Rezoning Transportation Analysis
Petition Number: Insert Zoning Petition #2022-052
General Location Identifier: 05911329

From: Jake Carpenter, PE
Jacob.Carpenter@charlottenc.gov
980-221-5675

Date	Description
08-24-2022	First Review (KP)

SHEET NO.
RZ-1

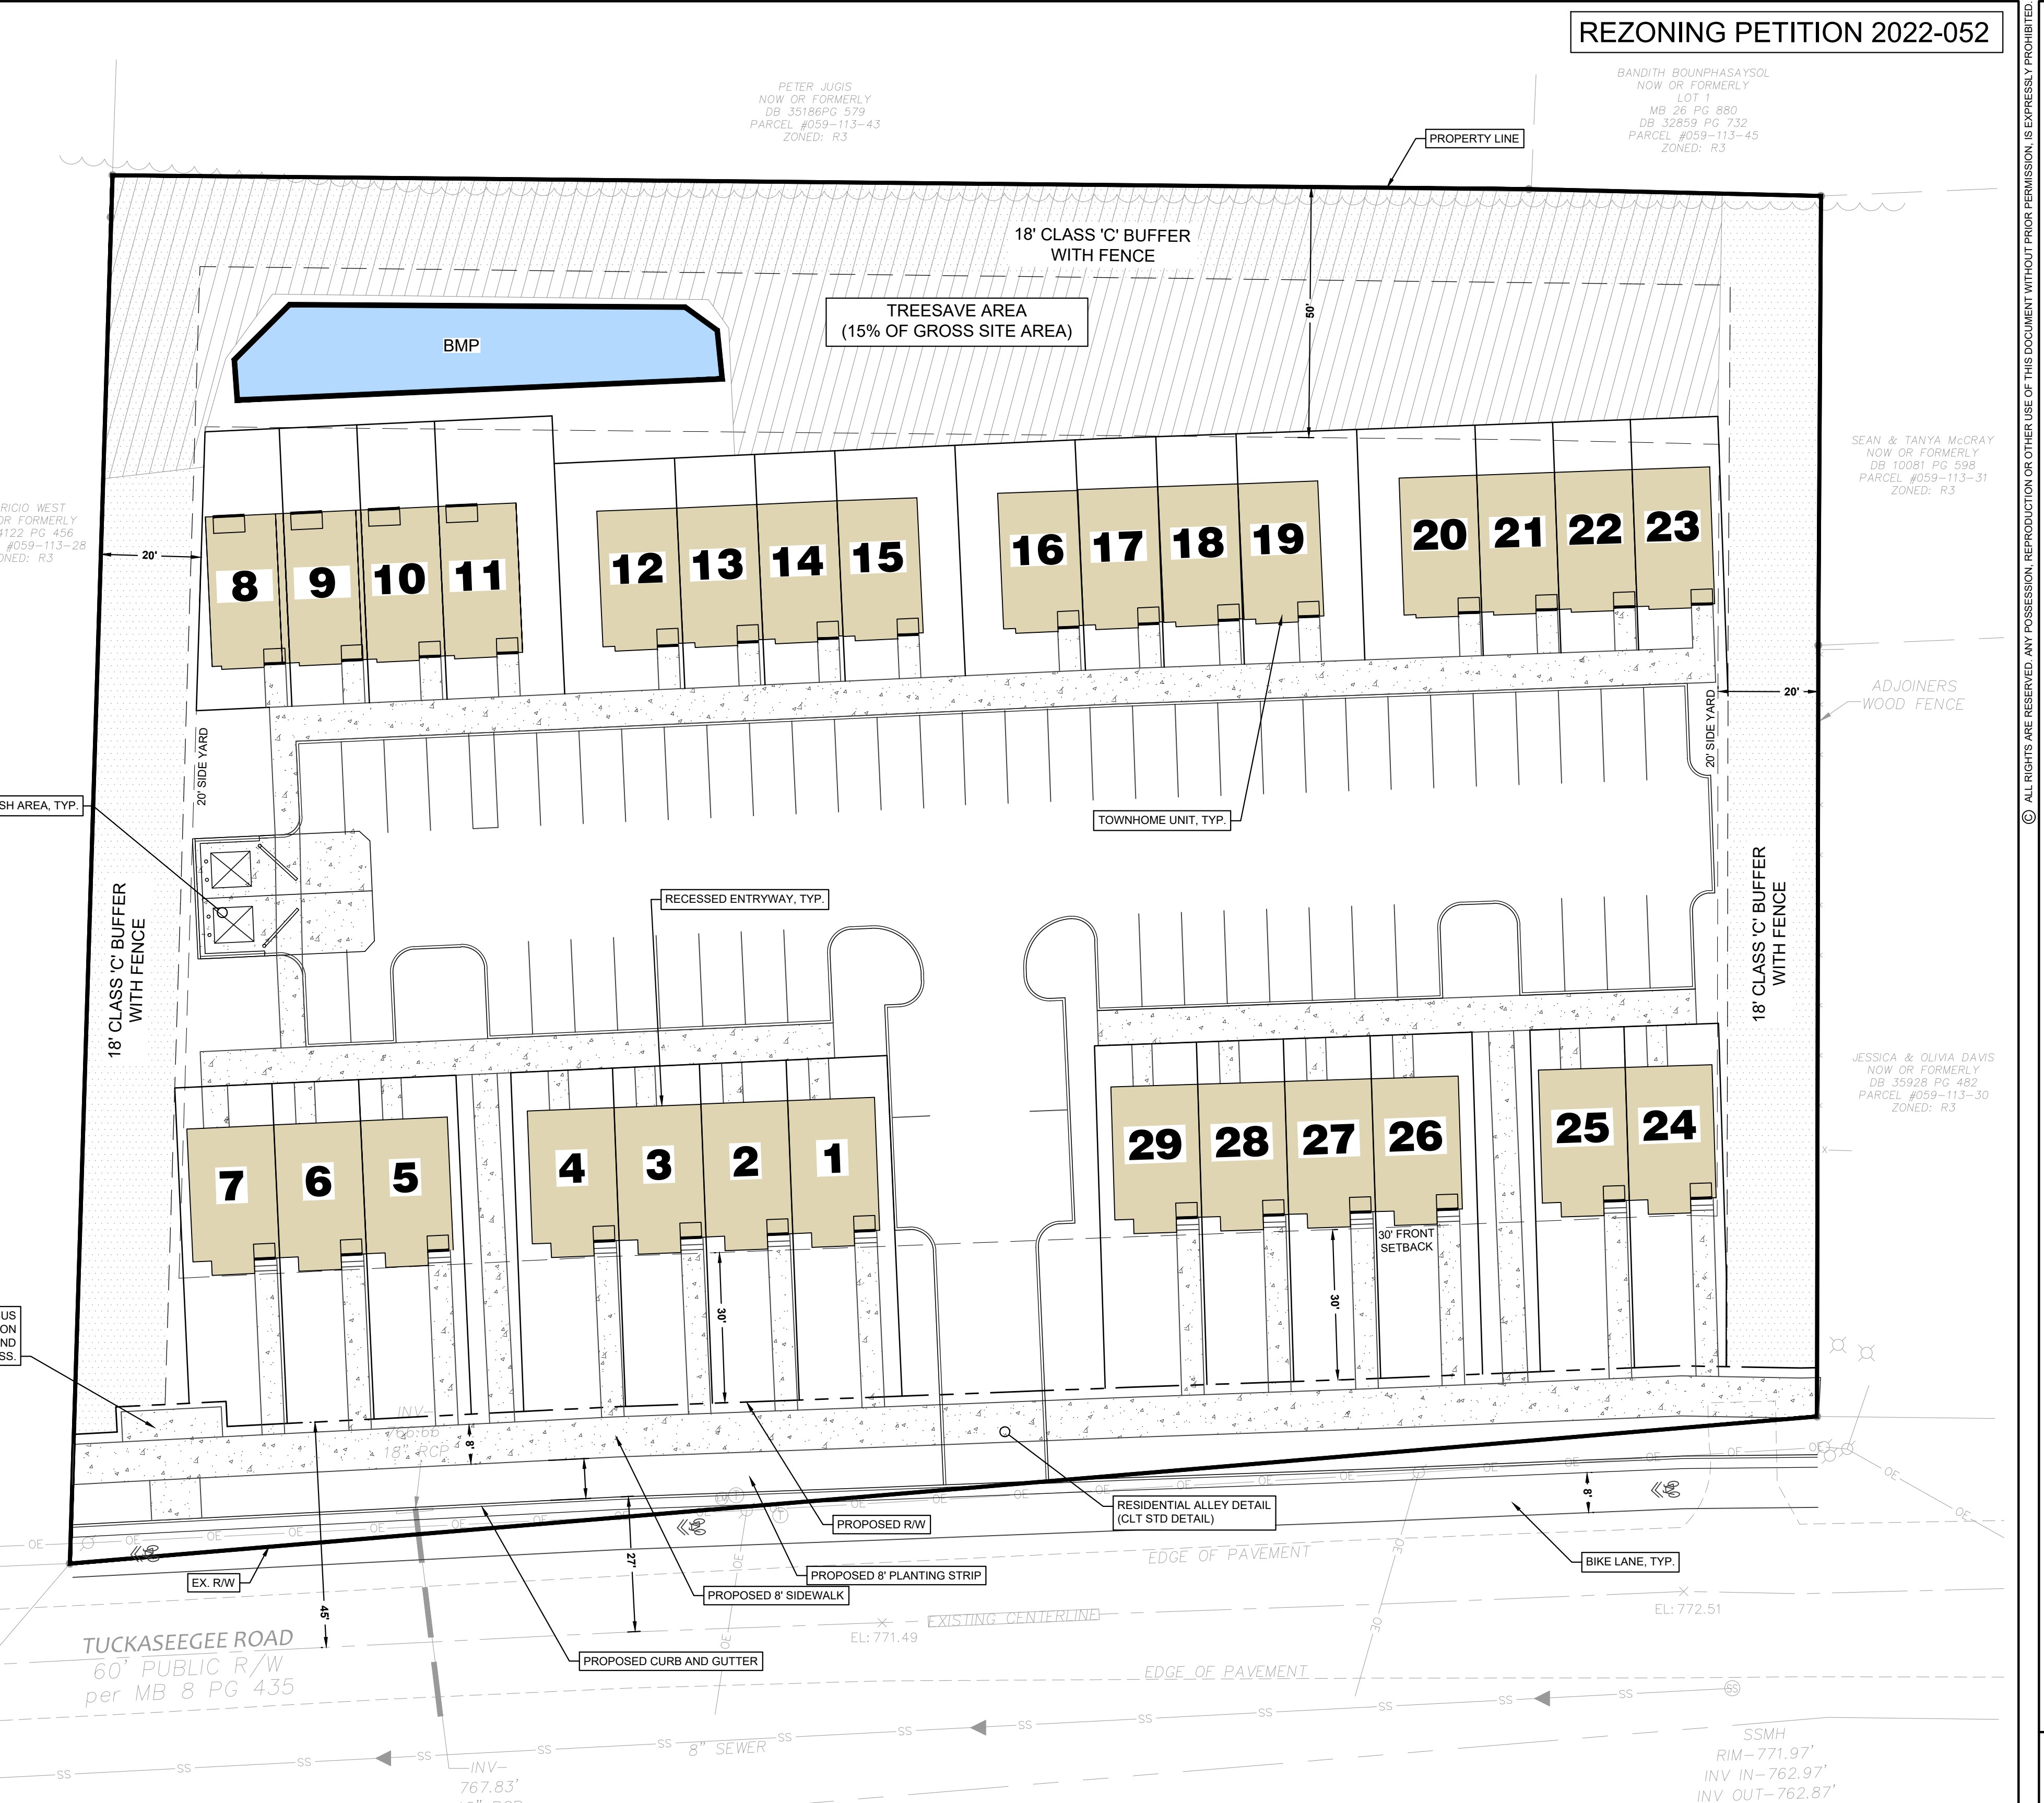
1. Revise the site plan and conditional notes by committing to construct curb and gutter, along the site's frontage of Tuckaseegee Road, measured 27-feet from the existing centerline to back of curb.

Label and dimension the back of curb from the existing centerline of Tuckaseegee Road.

3. Revise site plan and conditional note(s) to commit to dedicate 45-feet of right-of-way along the site's frontage of Tuckaseegee Road.

The site plan shall label and dimension the right-of-way from the road centerline.

4. Revise site plan and conditional note(s) to commit to construct an 8-foot planting strip, and 8-foot sidewalk along the site's frontage of Tuckaseegee Road. The site plan shall label and dimension both items from the back of curb and gutter.

5. Revise the site plan and conditional notes to commit to provide an 8-foot buffered bike lane along the site's frontage of Tuckaseegee Road. The site plan shall label and dimension the bike lane.
